Ribble Valley Borough Council
Council Offices
Church Walk,
Clitheroe
Lancashire
BB7 2RA

Phone: 0300 123 6780
Email: developeras@lancashire.gov.uk
Your ref: 3/2025/0794
Our ref: 3/2025/0794/HDC/KW
Date: 16 October 2025

Location: Old Dairy Farm Chipping Road Chaigley BB7 3LS
Proposal: Prior notification for proposed change of use of an agricultural building to office use including ancillary parking and open space under Schedule 2 Part 3, Class R of the GDPO.
Grid Ref: 369111 441517

Drawing file: planx_downloads / 25_0794_6811E00_Location_Plan_29Sep25.pdf

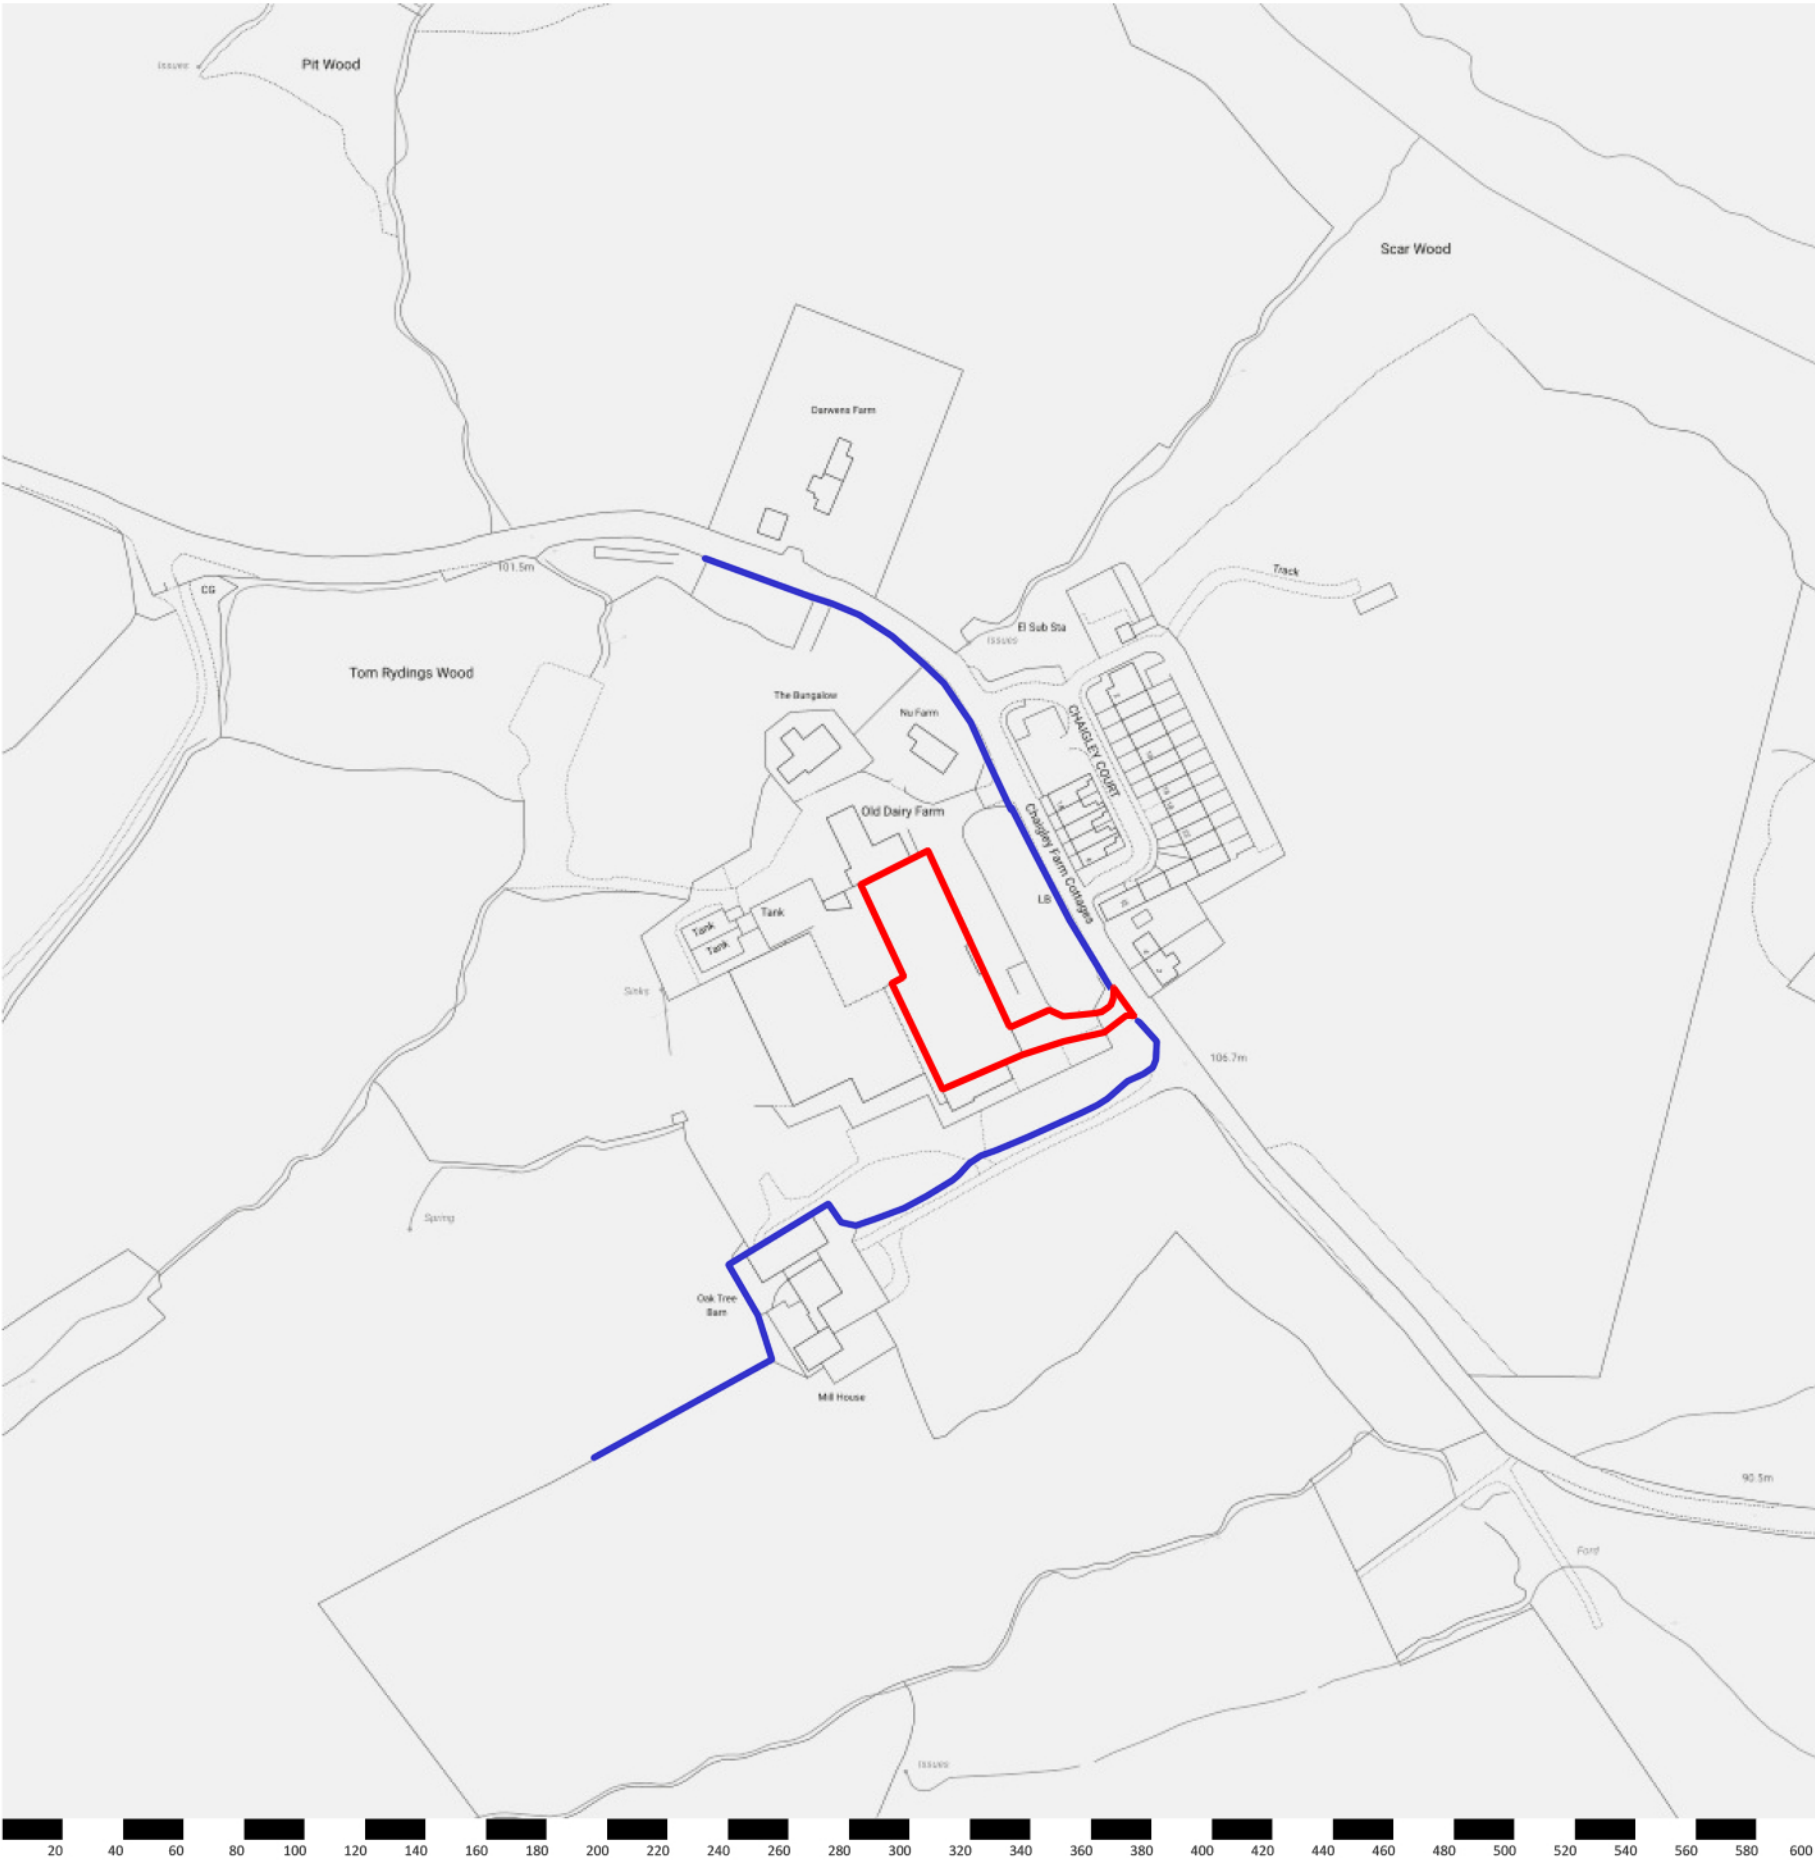
The site has two existing access on to Chipping Road which is classified as the C354 with a national speed limit fronting the site access. The access which sits further southeast has been highlighted within the red edge of the location plan as such the LHA view that this access will be used to serve the units.

However the applicant has not included a detailed site access plan within the supporting documents; as such the LHA requests that a site access plan be provided. The applicant should also advise whether the access will be used solely for the proposed offices or if it will continue to be used by agricultural vehicles. The LHA would expect the access to be at least 6m wide for 10m into the site.
